Application for a Non-Material Amendment Following a Grant of Planning Permission

Demolition of existing bungalow and redevelopment as 2-storey dwellinghouse with loft conversion and associated external works and alterations [Amended Description].

23/1378/F

Proposed Front Elevation
Scale 1:100

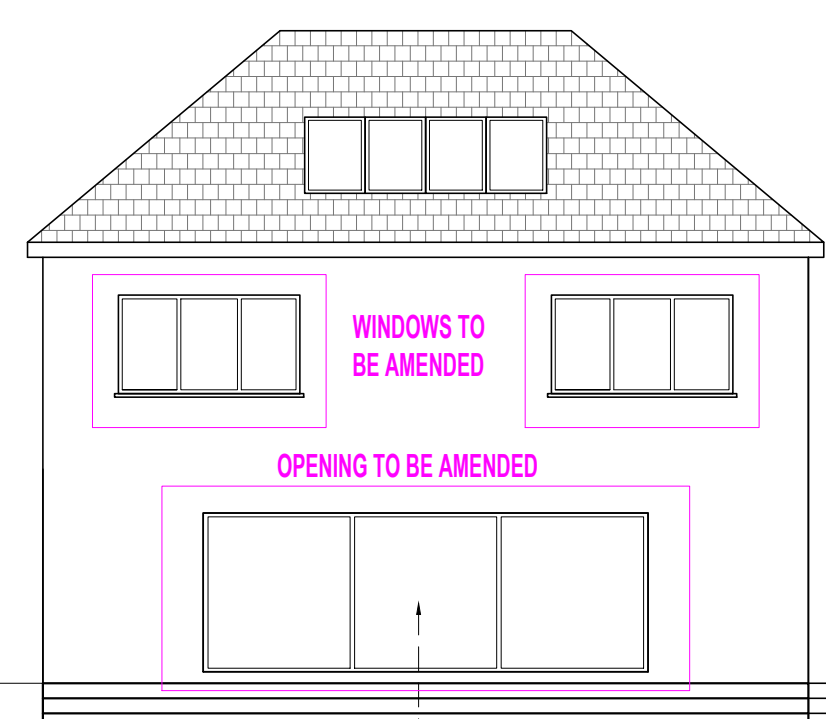
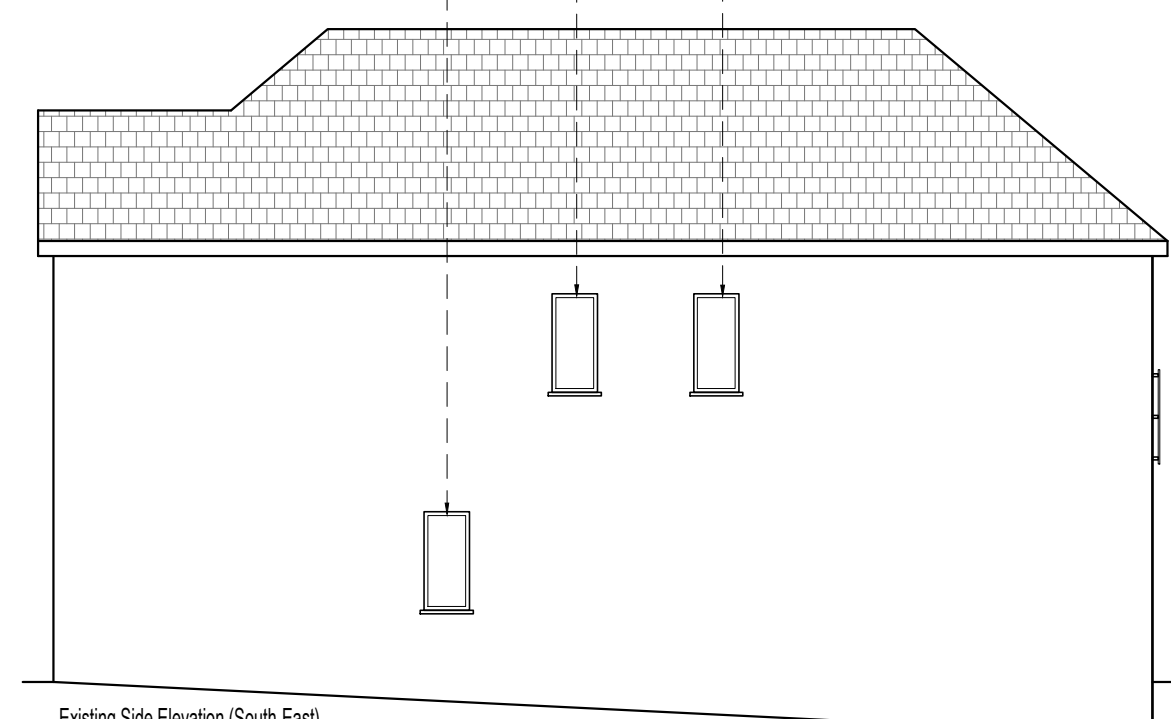
Widening of the ground floor opening to the rear garden from 5.88m to 7m.
Reshaping of the 2 first floor windows at the rear (2.4x1.3m) to convert them into juliet balconies (2x2.1m).
Relocation of the glass elements (26.5cm towards the front) to achieve a continuity on the front facade.
